From: Amanda Scholes on behalf of Planning.Responses
Sent: 20 May 2019 09:35
To: Planning Scanning
Subject: FW: CM/4/19/PL - Crematorium - Land South of A259 Grevatts Lane, Climping
Attachments: BWREDE17 Grevatt's Lane, Climping Exception Report.docx

**SAFETY AUDIT EXCEPTION REPORT
FOR DEVELOPER PROMOTED SCHEMES**

| DRAWING NO:  | SC-CLMPG-V1-XX-DR-K-0500 | REVISION: | F        |

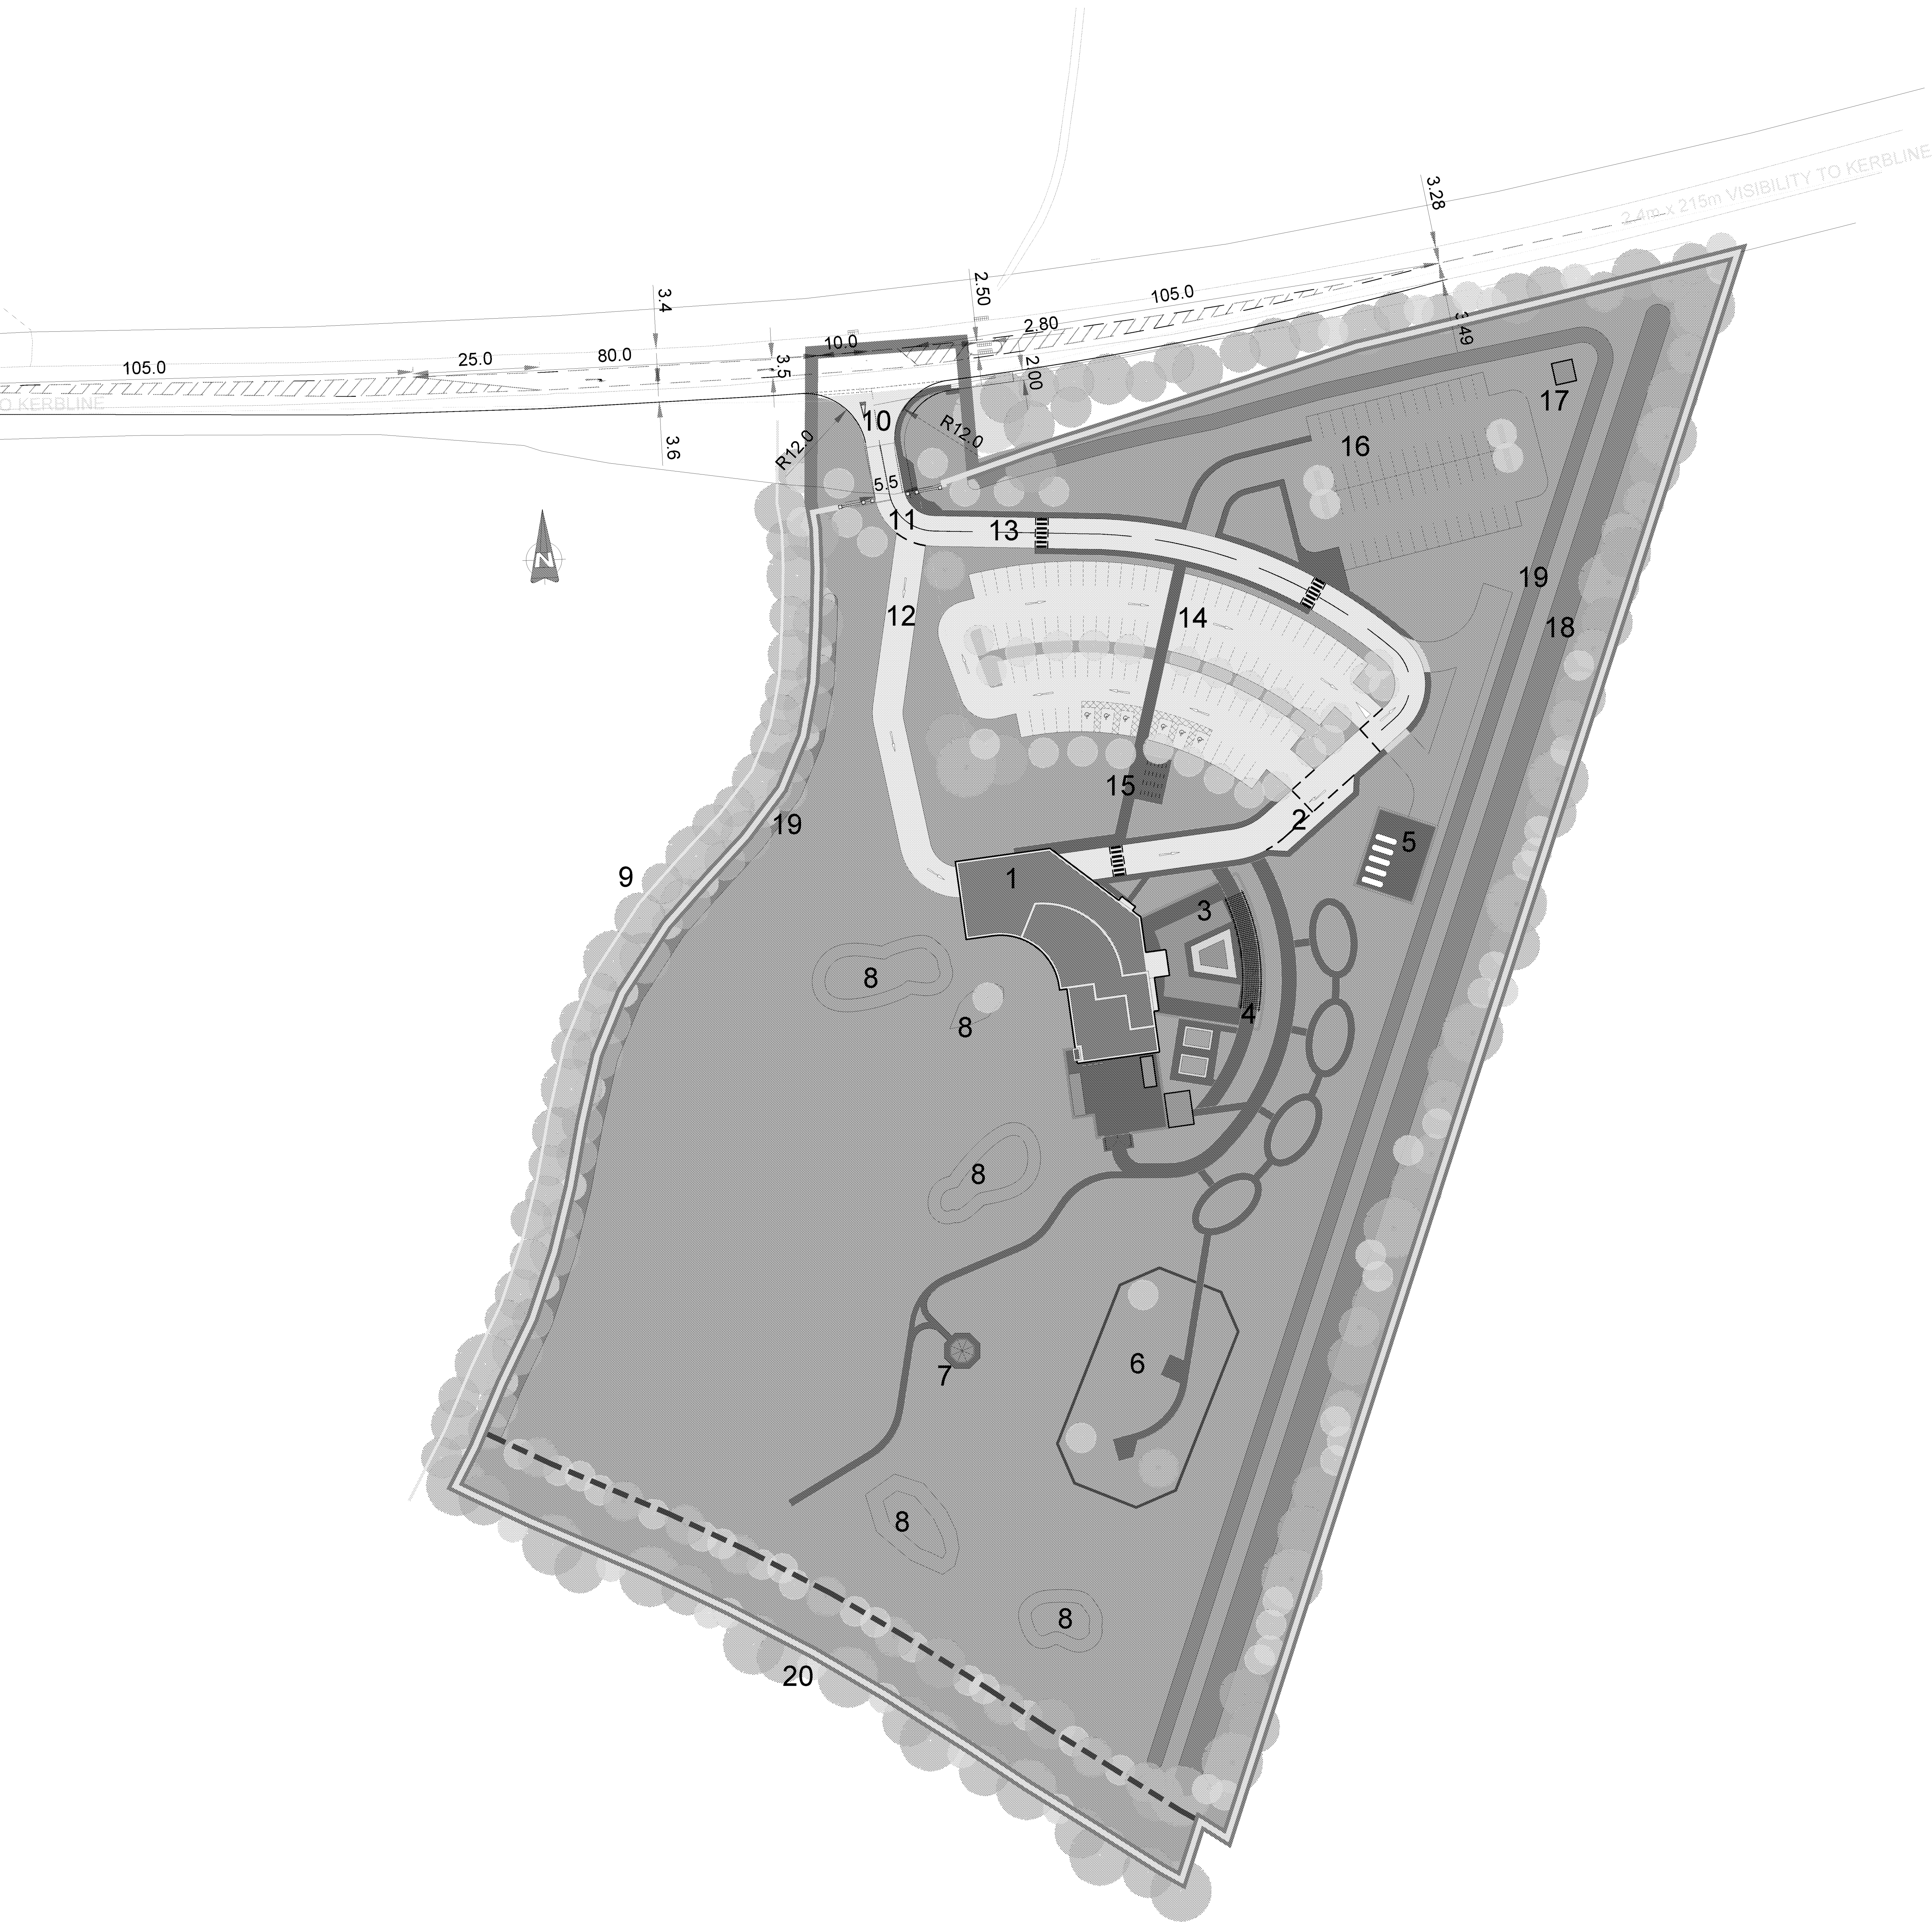
Thanks for the additional information. I have done some internal consultation and can confirm that an exception report would be required regarding the safety audits recommendation of reducing the speed limit which the designers response does not fully accept nor would WSCC require this.

Anita,
Thanks for forwarding on, I'll take a proper look at this tomorrow but at first glance an exception report is likely to be required over the speed limit issue and further design work required if the gates are on existing highway land.

One element of information requested and yet to be provided is junction modelling of the site access. Are you able to remind the applicant of this request.

Para. No.	Problem (as identified by Safety Auditor)	Recommendations (made by Safety Auditor)	Designer's Response	Proposals
3.6	Potential for Speeding. The widening of the carriageway in this location may encourage increased vehicle speeds. Services at the crematorium are likely to be tidal and may involve a greater proportion of elderly drivers. There is potential for risk of collisions between through traffic and turning vehicles.	It is recommended that the speed limit is reduced over this section of highway.	The existing Grevatt's Lane carriageway measures between 6.8m and 8.3m wide in the vicinity of the site, with existing lane widths of between 3.3m and 4.5m wide (narrowing from west to east). The through-lane widths have therefore been either retained as existing or narrowed over the length of the proposed site access and measure 3.4m and 3.6m wide. This is in accordance with DMRB TD42/95 guidance (Paragraph 7.20) which states that, 'at ghost island junctions, the through lane in each direction shall not be greater than 3.65m wide, exclusive of hardstrips, but shall not be less than 3.0m wide.' The proposed general arrangement drawing has been updated to show the existing lane widths at either end of the junction (drawing number BWREDE-SK01-P5). A review of the accidents records in the vicinity of the site shows that there is not considered to be an existing road safety concern in the vicinity of the site, and there are no injury accidents at the location of the proposed access junction. The proposed access junction is likely to experience less vehicle movements than the nearby access junction at Baird's Business Park / Hobbs New Barn which is also located within the national speed limit section of Grevatt's Lane. However the proposed access would benefit from a designated ghost island right turn lane. Nonetheless, should WSCC require that the speed limit is reduced along this section, the client would be willing to pay a contribution towards the consultation of a Traffic Regulation Order (TRO) to reduce the speed limit.	It is not proposed that a reduction in speed limit along this stretch is required. This is due to the factors identified in the Designer's Response. WSCC have, in their e-mail dated 13th May 2019, identified that WSCC does not require a reduction in speed limit. The proposed site access has been designed in accordance with DMRB requirements for a road with a speed limit of 60mph (with speeds recorded at lower than 60mph) and therefore it is not considered that any further design changes need be made.

Please see the attached Site Access Assessment in response to your colleague's comments. We have also updated the site plan, relocating the entrance gates slightly to ensure that they are not on highways land, and a copy of that is also attached.

Please see the attached highways report which includes the results of the Road Safety Audit together with a response from our consultant. The site plan has also been updated to address the comment in relation to the entrance to the overflow parking area and a revised copy of that is attached also. I trust that this will address the queries raised by your highways colleagues but if anything else is needed in this regard please let me know.
